Water & Sanitation District No. 1

March 30, 2020

RE: North Bay

"AS REPLATTED"

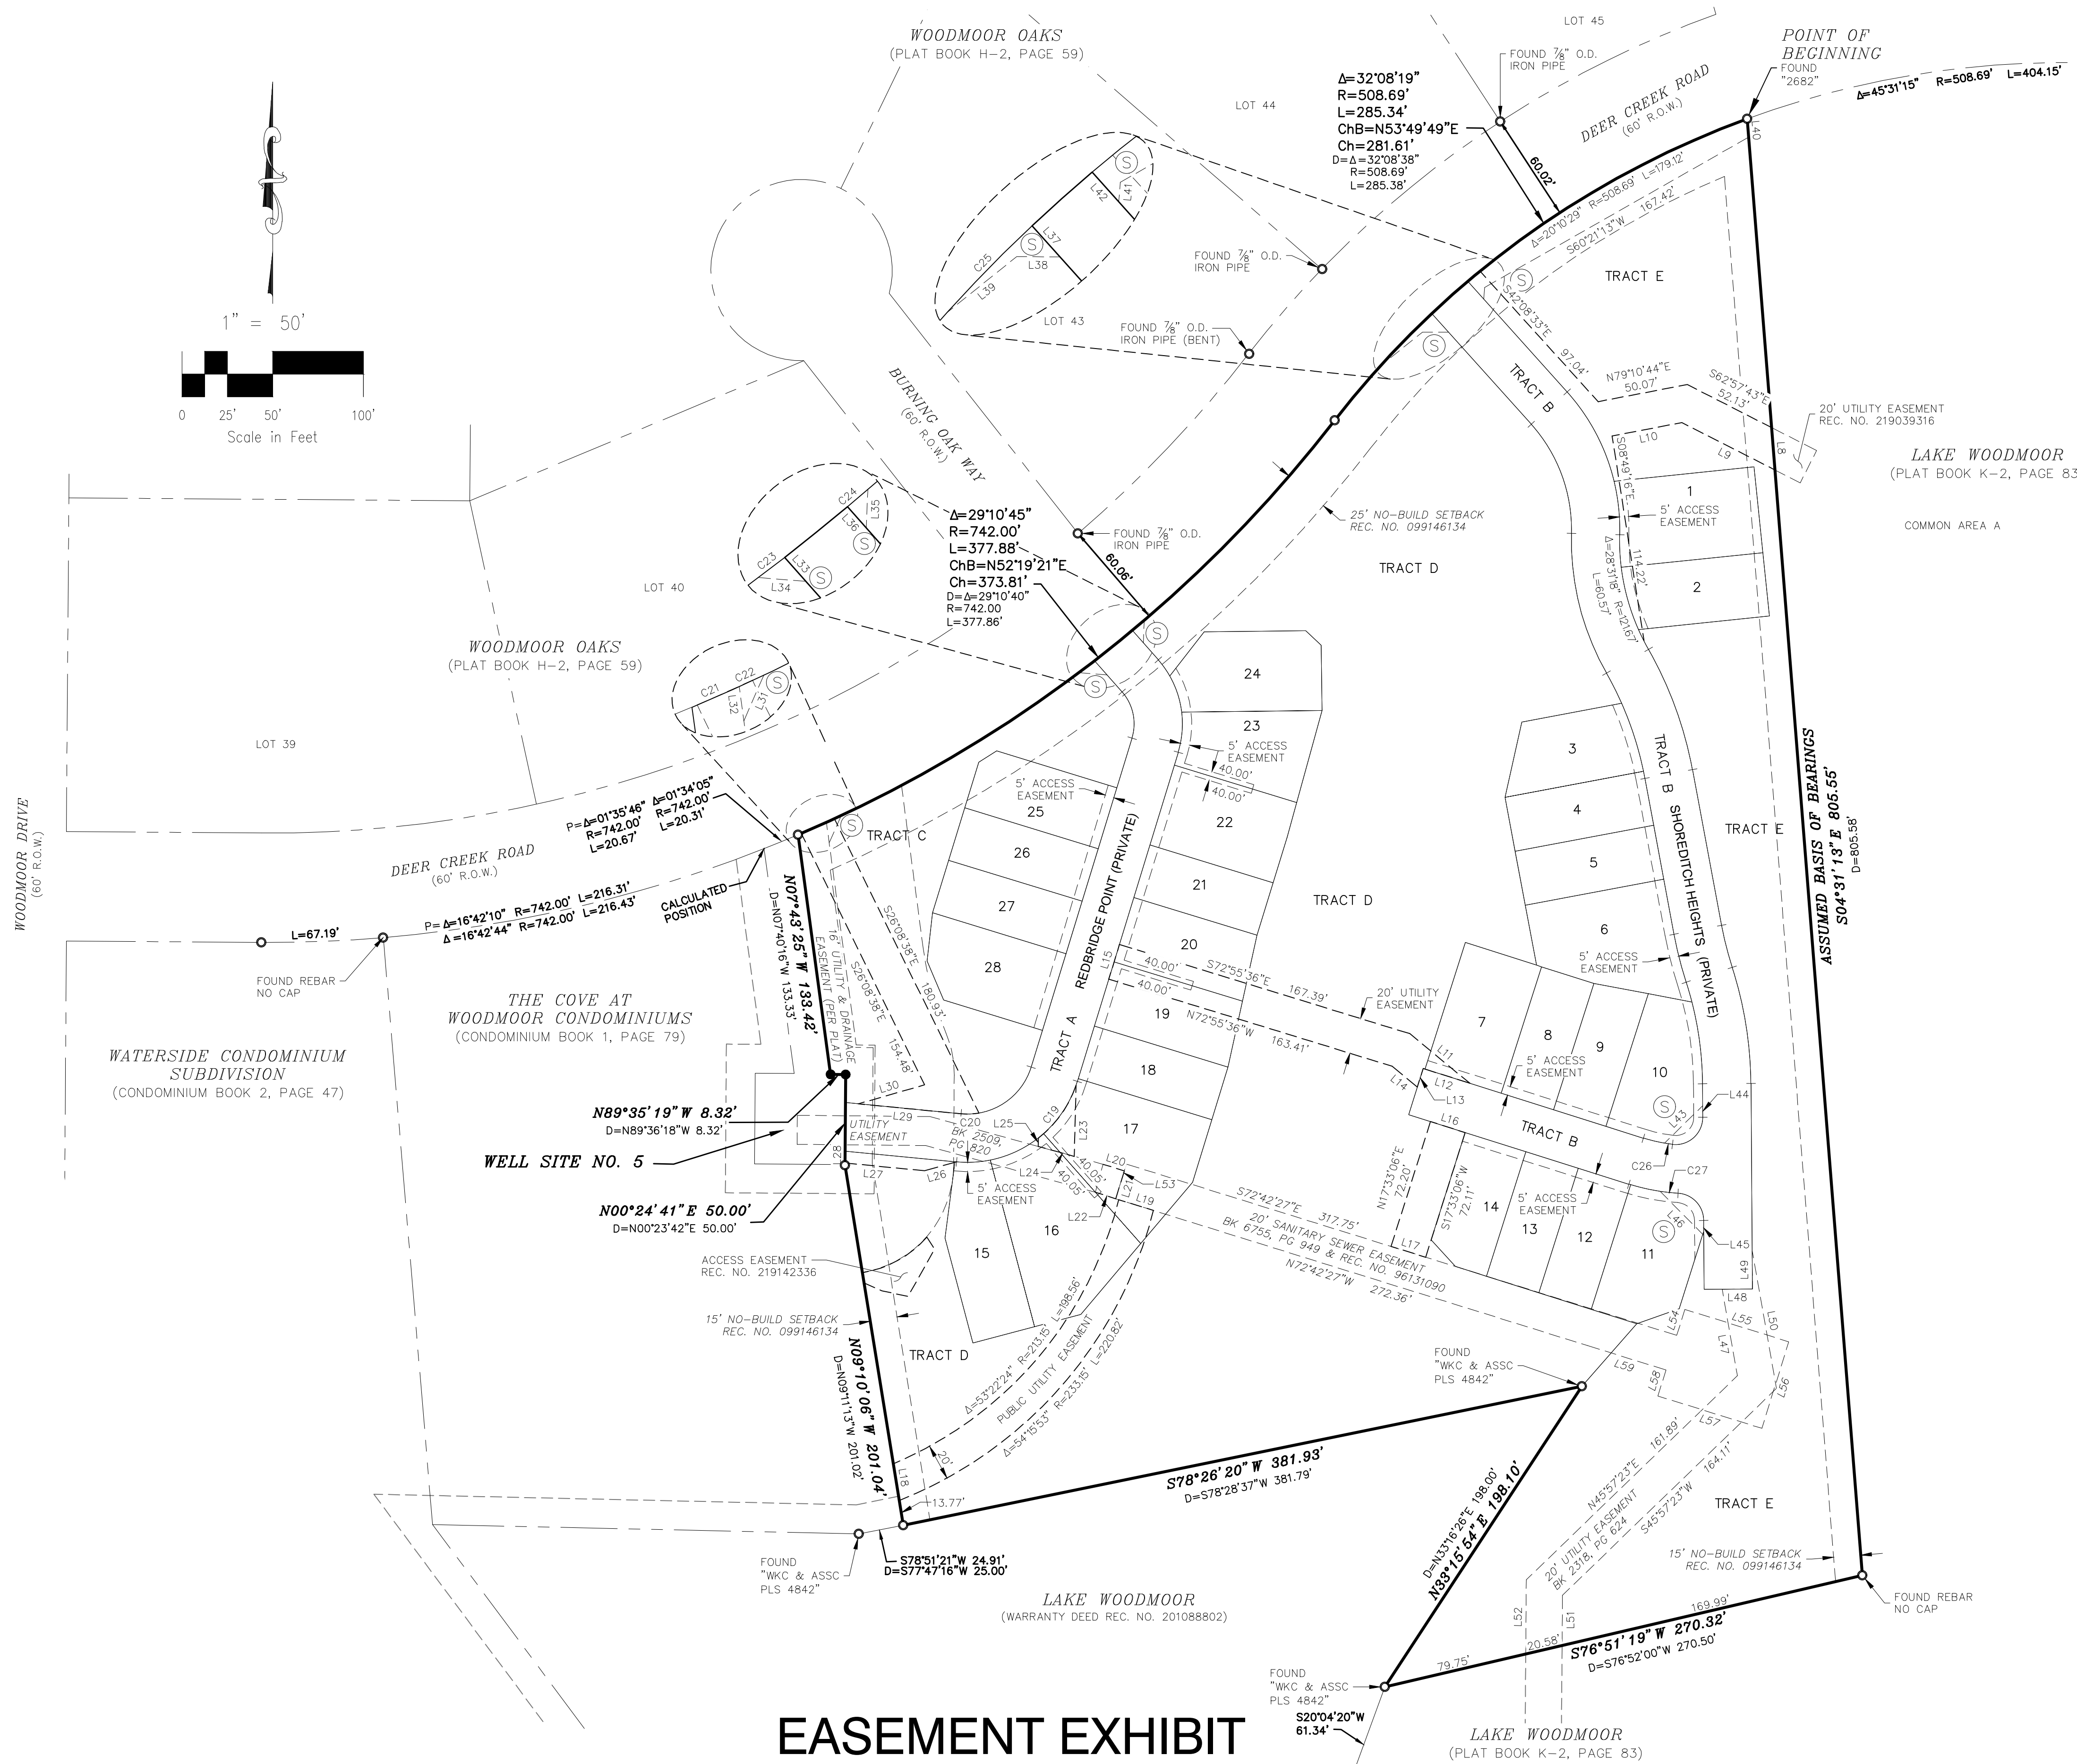
1. Where labeled “20’ UTILITY EASEMENT”, by Tract E and within Tract D, please change to “20’ PUBLIC UTILITY EASEMENT”.
2. To the west side of Lot 14, there is a dotted line. Is this indicating an easement? If so, please label and note the size.
